**Liddell Battery and Bayswater Ancillary Works Project (SSD-8889679) - Review of Environmental Impact Statement**

BCD have reviewed the Environmental Impact Statement, including relevant appendices, in relation to impacts on biodiversity and flooding.

Figure 6 - 1 Threatened flora surveys - PCT 1691 (vegetation zones 1, 3, 4)

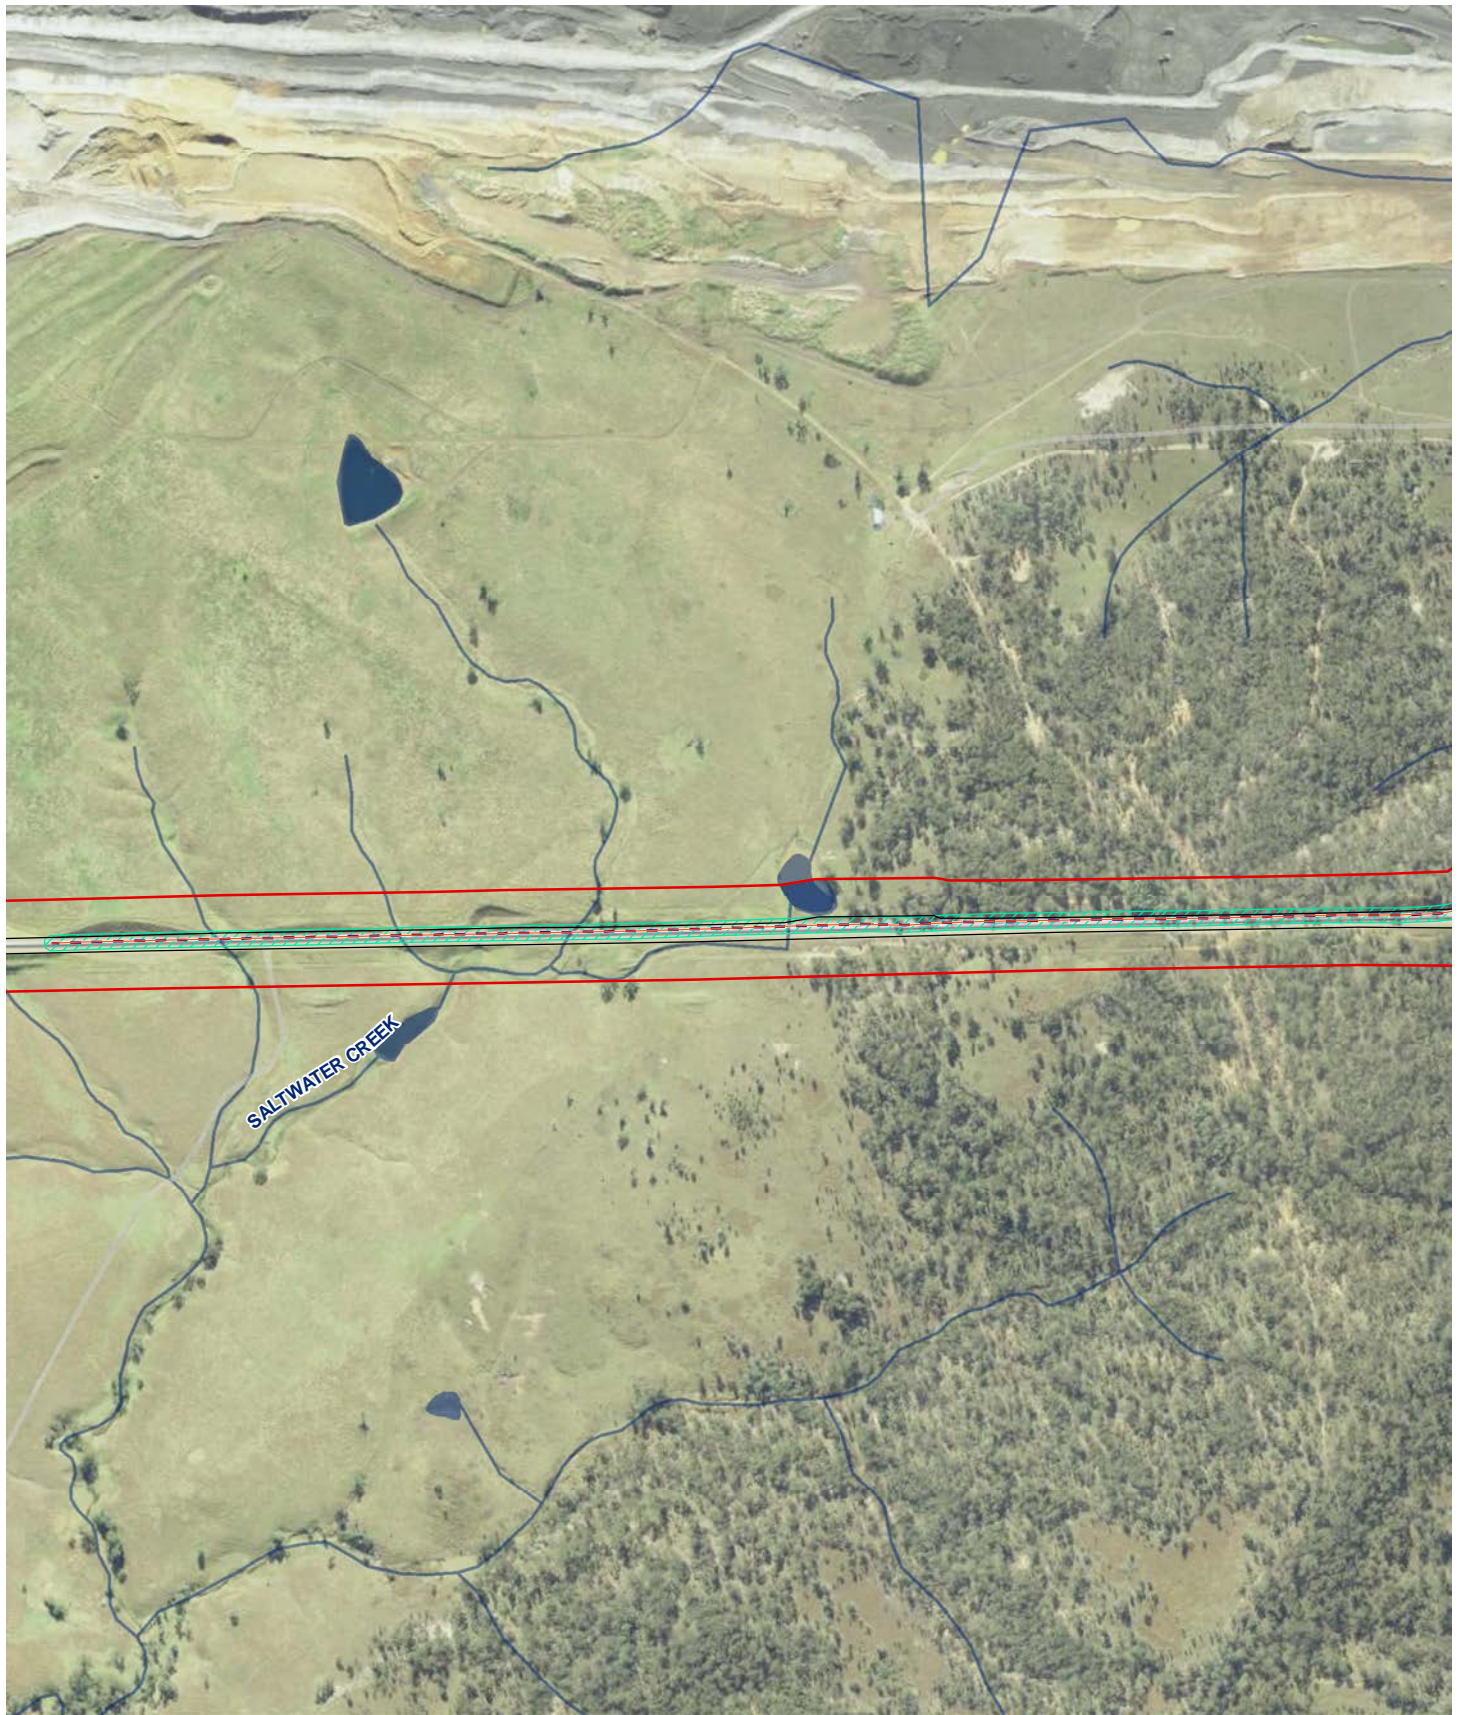
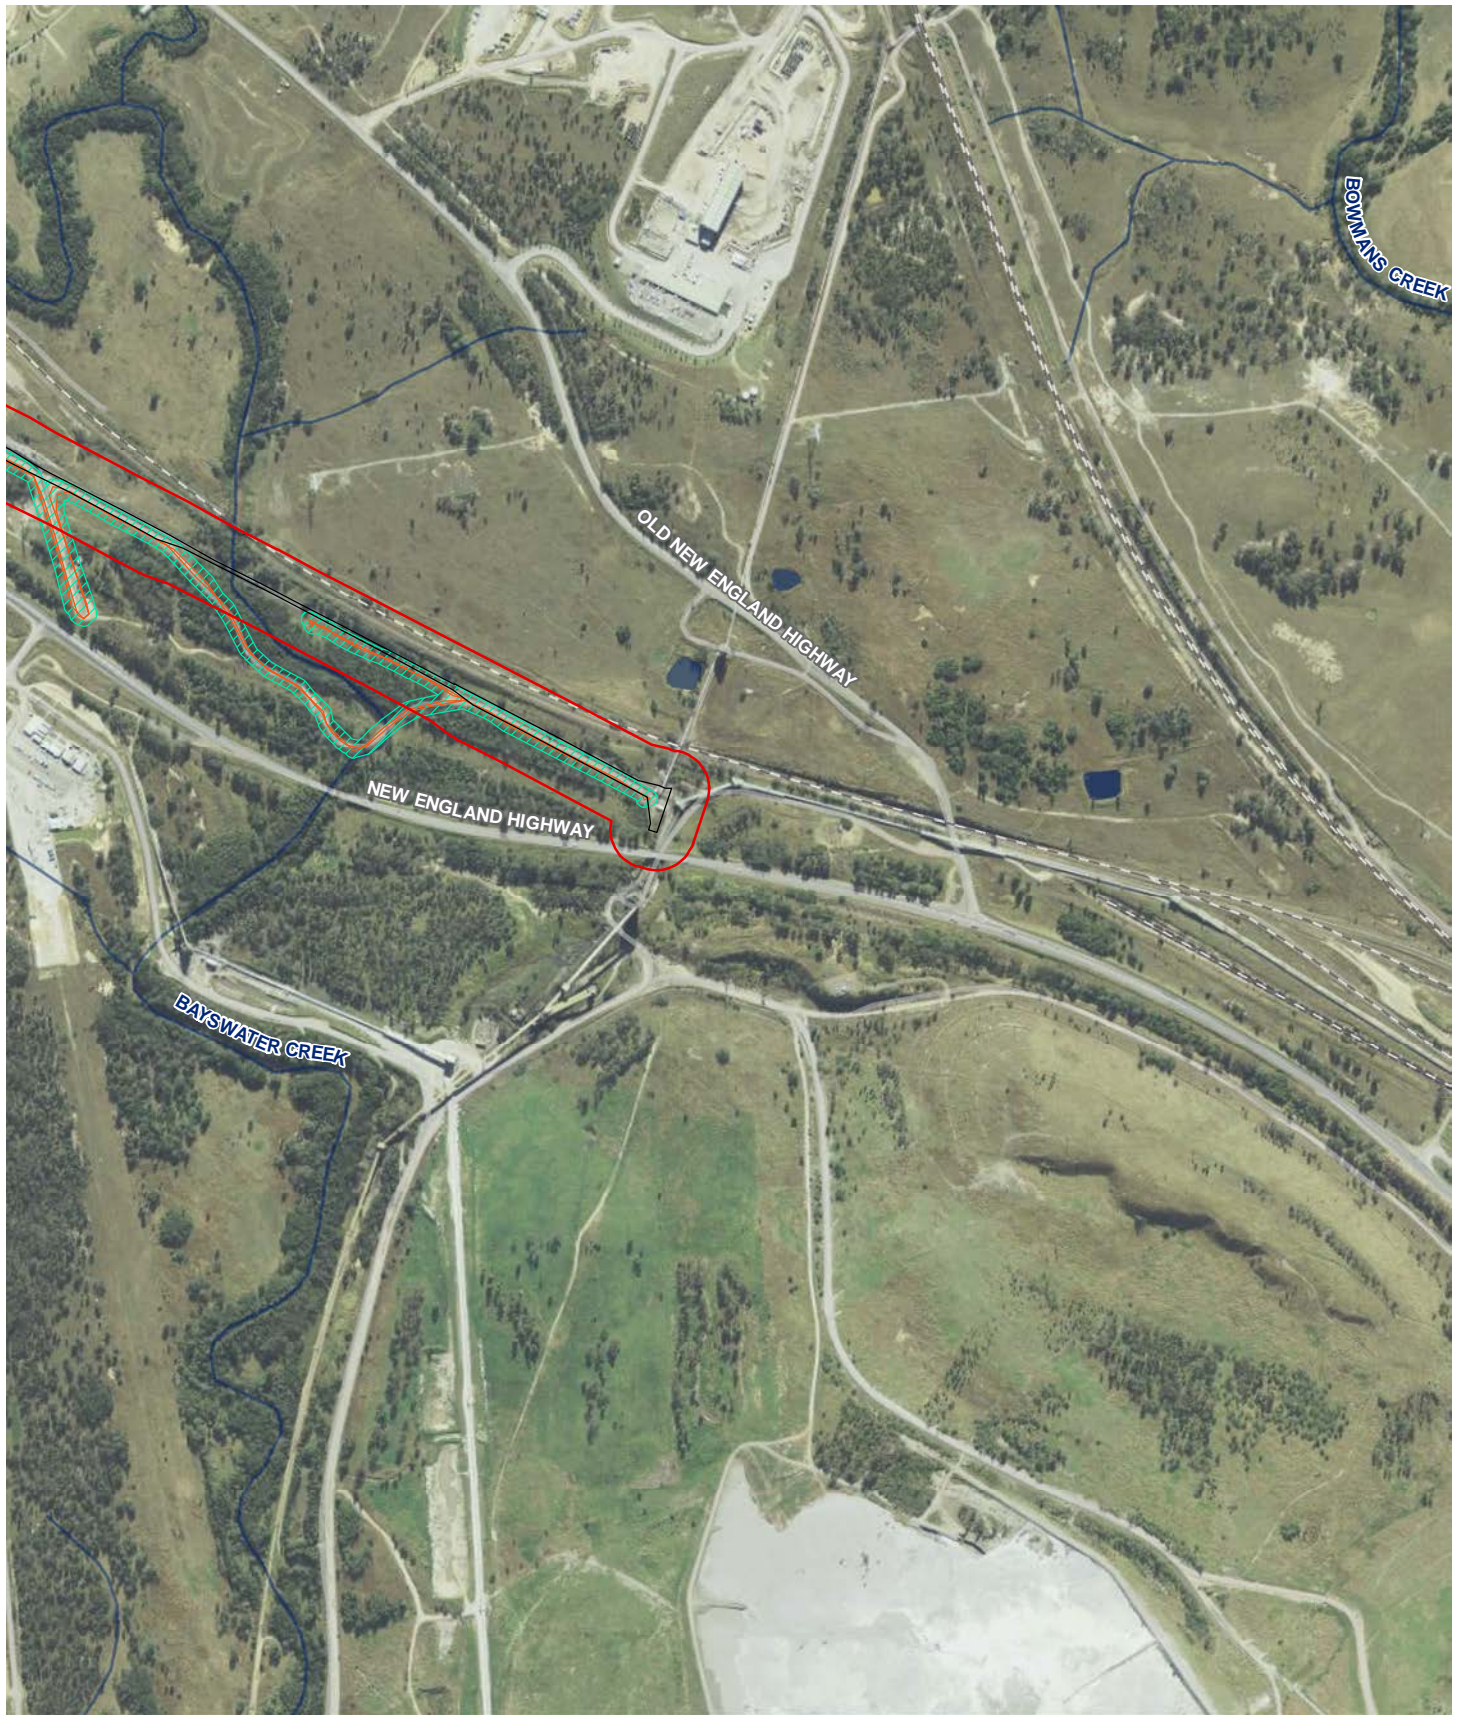
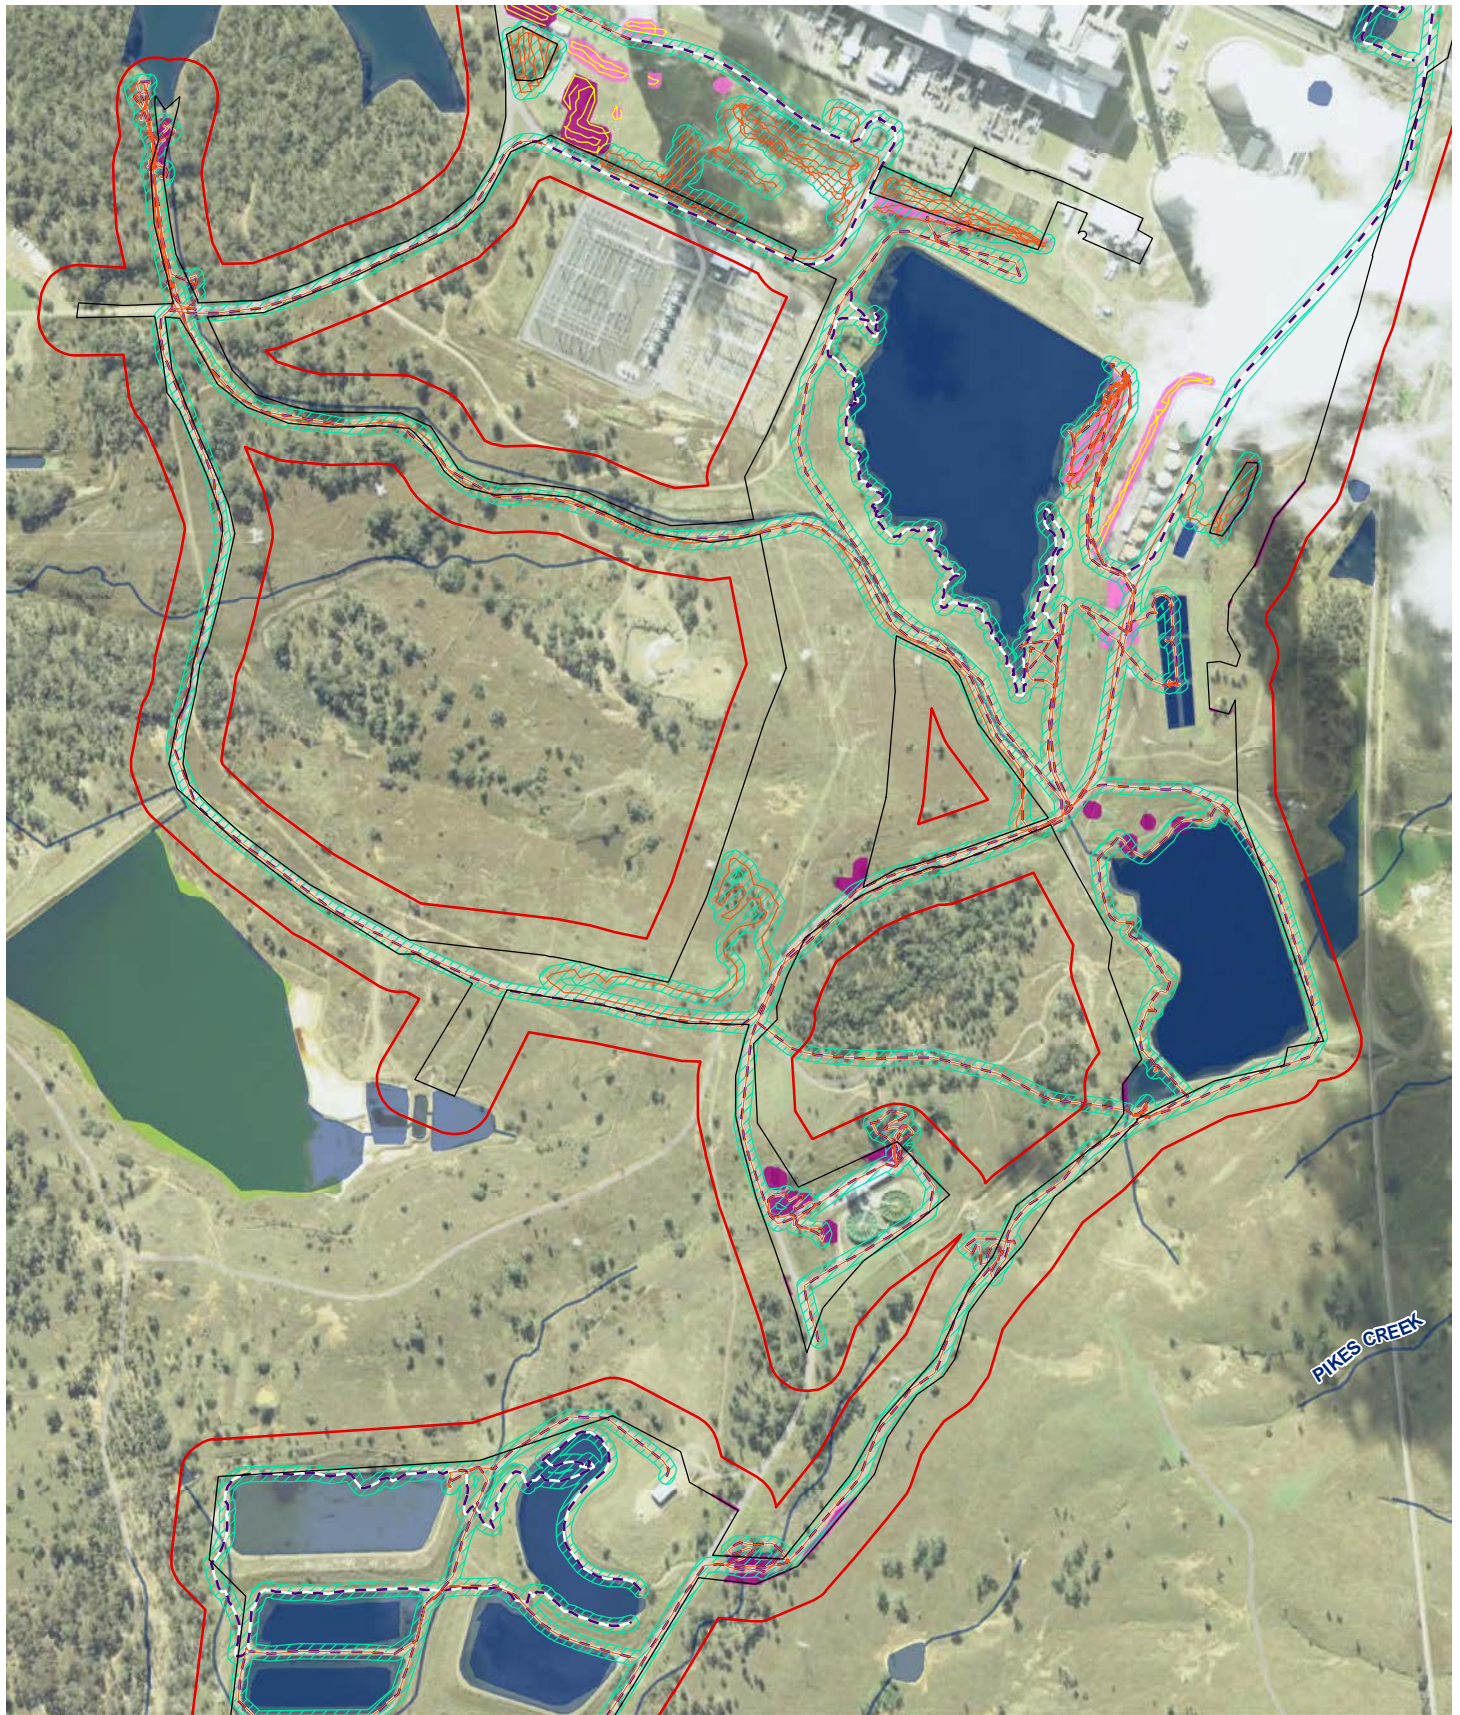
#### 4. Targeted surveys for the threatened plants will need to be shown clearly on revised maps

Section 6.3 of the BDAR describes survey effort for threatened plants, including the threatened ground orchids, *Diuris tricolor* and *Prasophyllum petilum* (syn. *Prasophyllum* species 'Wybong' under the *Environment Protection and Biodiversity Conservation Act 1999*). These orchids were considered not to be present on the development footprint due to targeted survey and Expert Advice from Dr Stephen Bell [Presented as Appendix G: terrestrial Orchid Survey – Expert Advice in the BDAR].

The targeted surveys are described on page 65 as being parallel transects five to ten metres apart in areas deemed to be suitable habitat based on Plant Community Type and vegetation condition (PCT 1691, PCT 1692, derived or modified native grasslands, and rehabilitation areas where exotic grasses were not too dense). The transects are shown on Figure 6-1 (pages 66 to 71 of the BDAR). However, the transects, and the underlying vegetation zones do not show clearly on the figures, which are shown at a scale of 1:25,000. BCD recommends that Figure 6-1 is revised to clearly show the areas where targeted searches were conducted for threatened orchids.

BCD recommends a new version of Figure 6-1 'Threatened flora surveys' is prepared, at 1:1,000 scale, that clearly shows the location of targeted flora surveys, and the vegetation zones in which they were conducted.
